September 11, 2023

RE: 4950 Jefferson St. NE
Grading and Drainage Plan
Engineer's Stamp Date: 09/05/23
Hydrology File: F17D026A

Based upon the information provided in your submittal received 09/01/2023, the Grading & Drainage Plans **are not** approved for Building Permit and Grading Permit. The following comments need to be addressed for approval of the above referenced project:

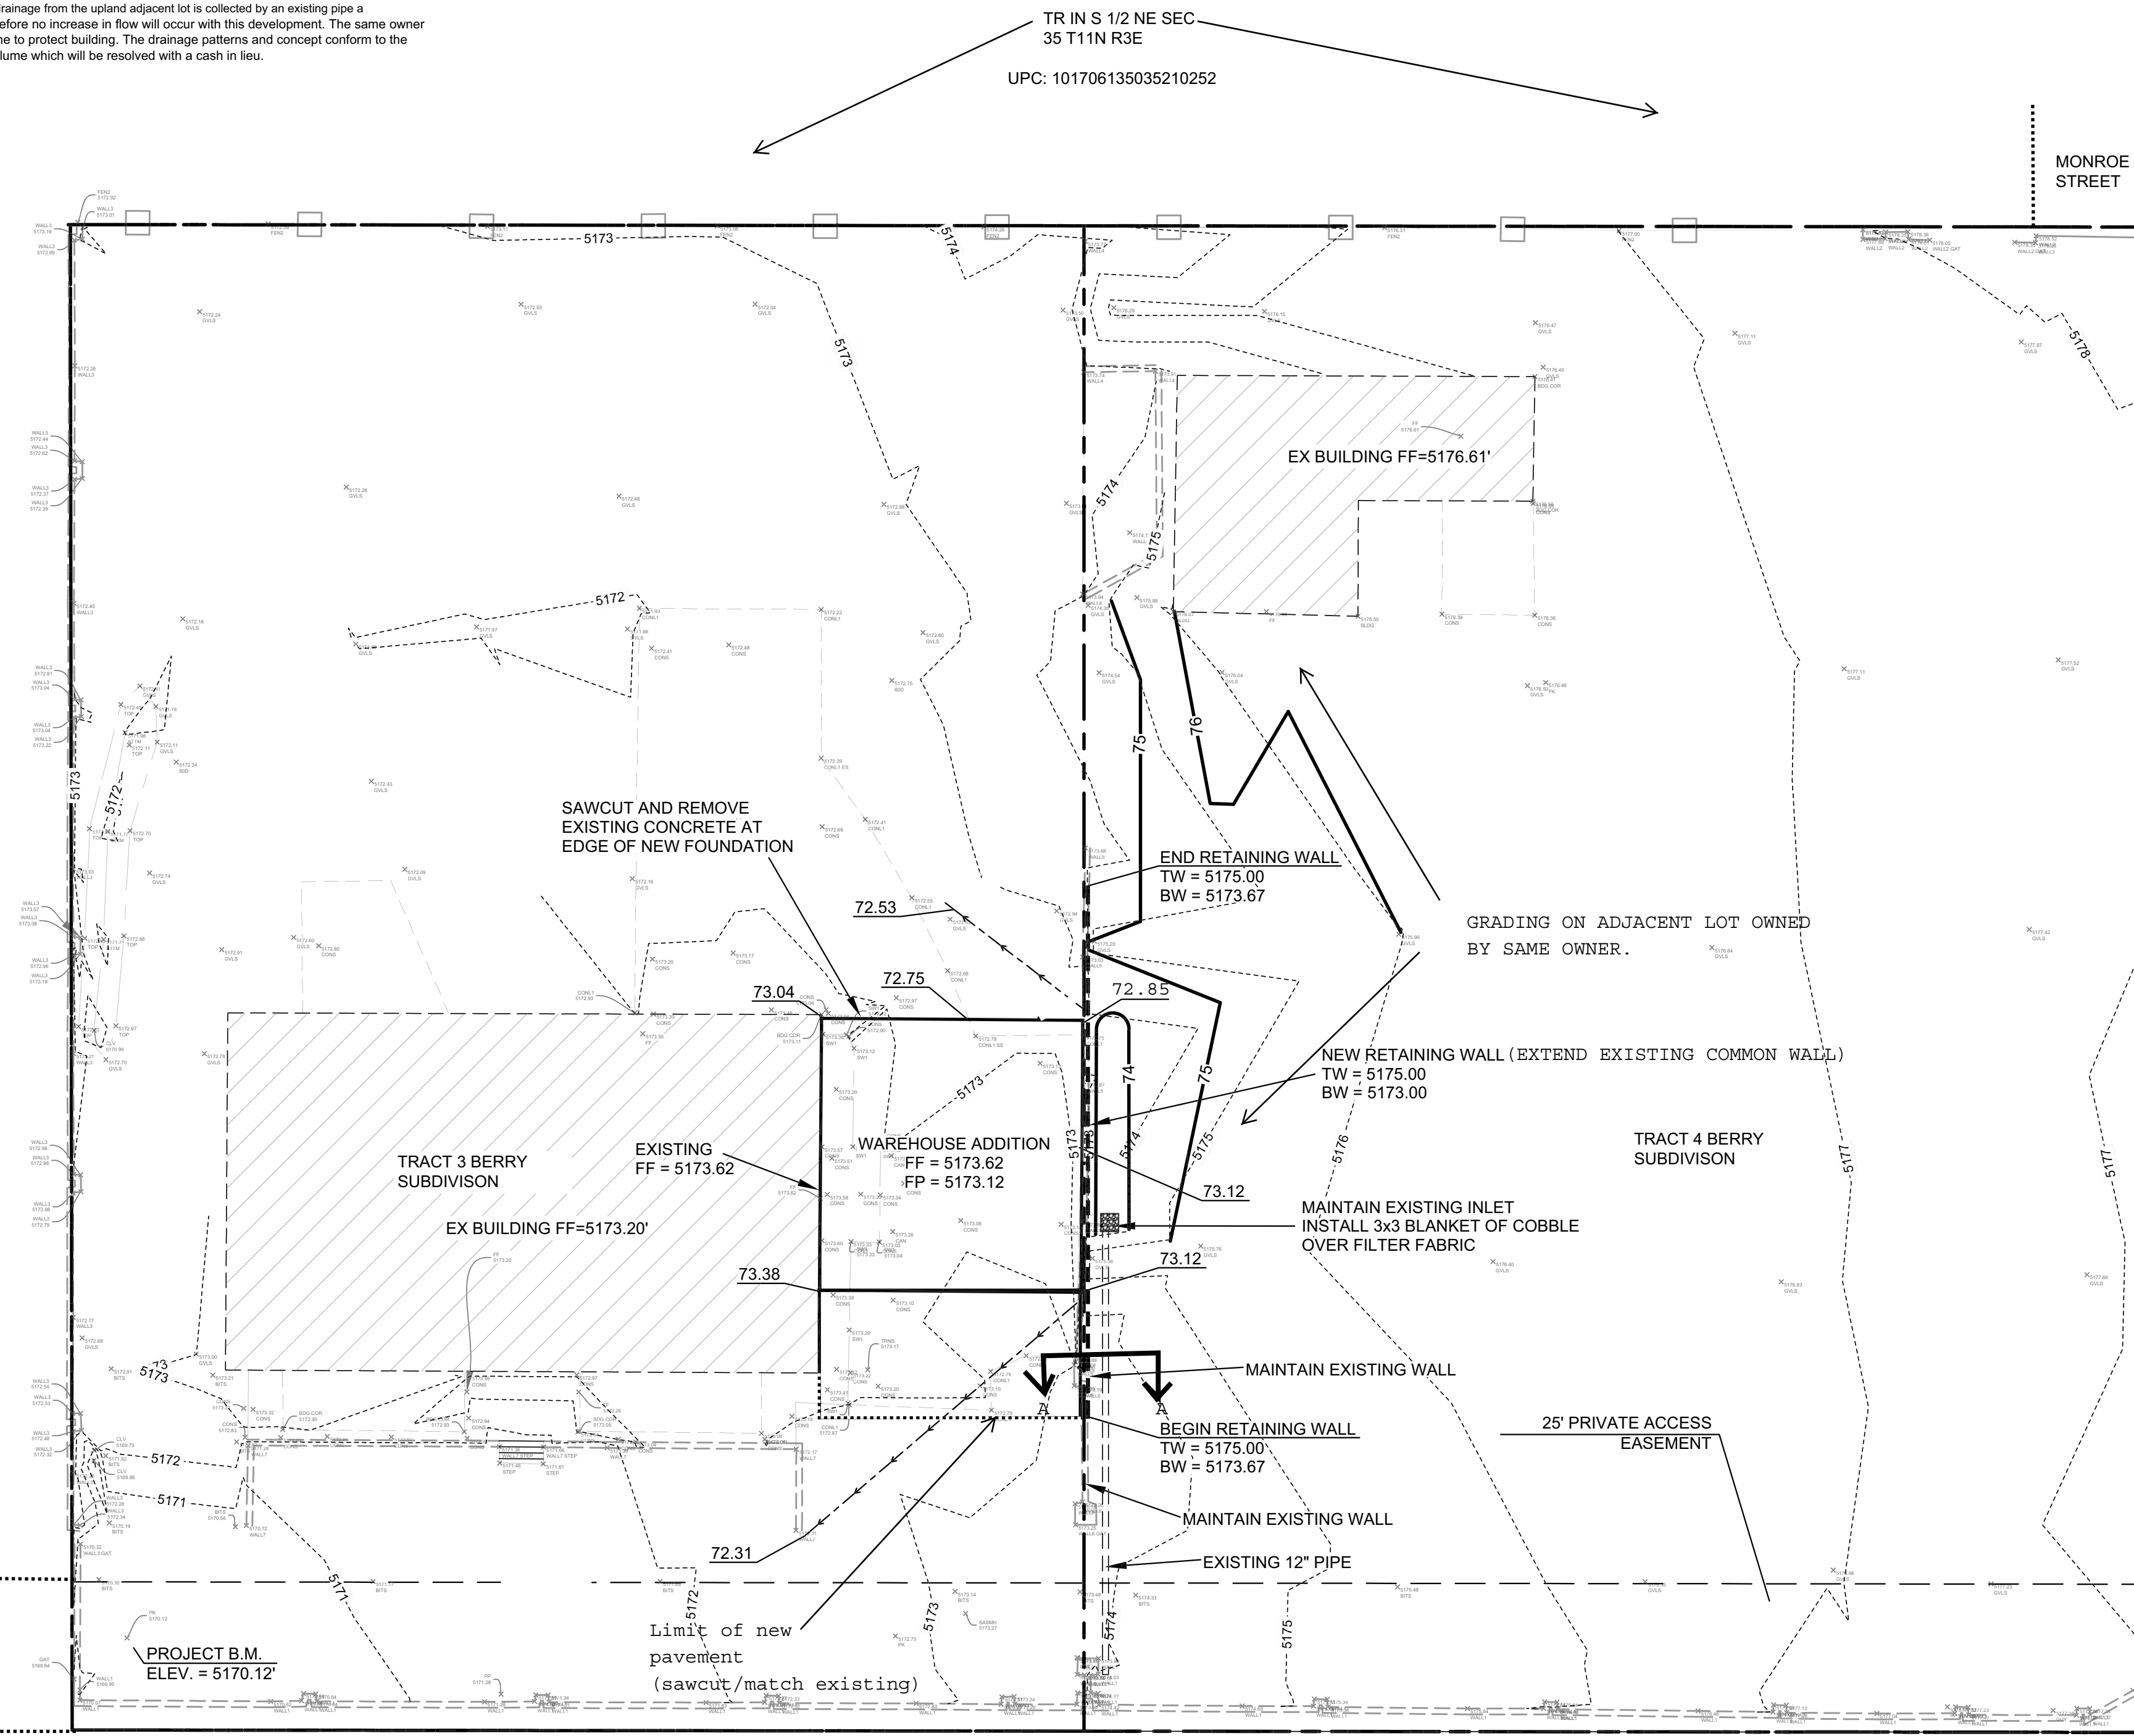
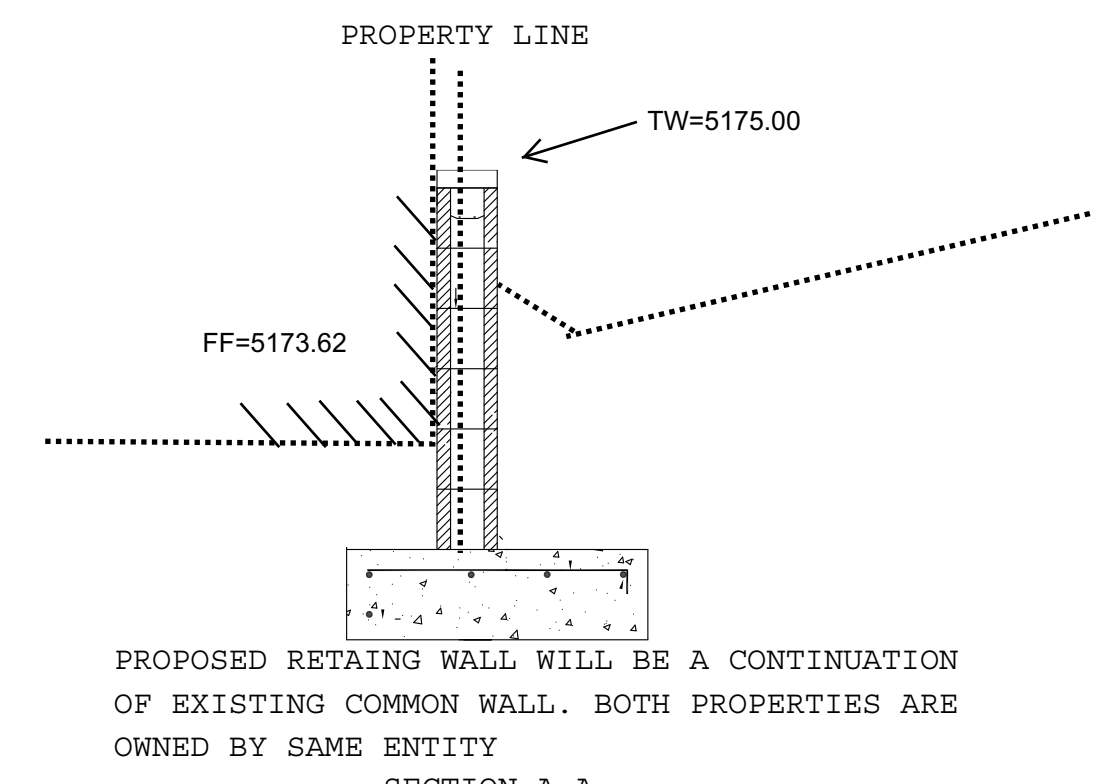
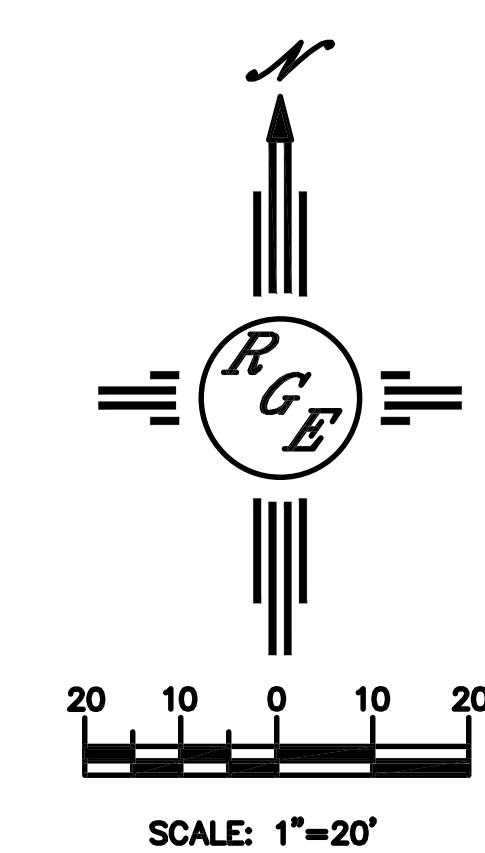
1. Please provide all adjacent property legal description.
2. Please show and label Monroe St. NE.

3. Please show the access easement on the adjacent property and label "Exist. Access Easement (To Jefferson St. NE)".

4. Please provide written. Signed, and notarized permission from the adjoining property owner (Same Owner) for work on that property.
5. Please add some more detail to the section between the two properties as shown.
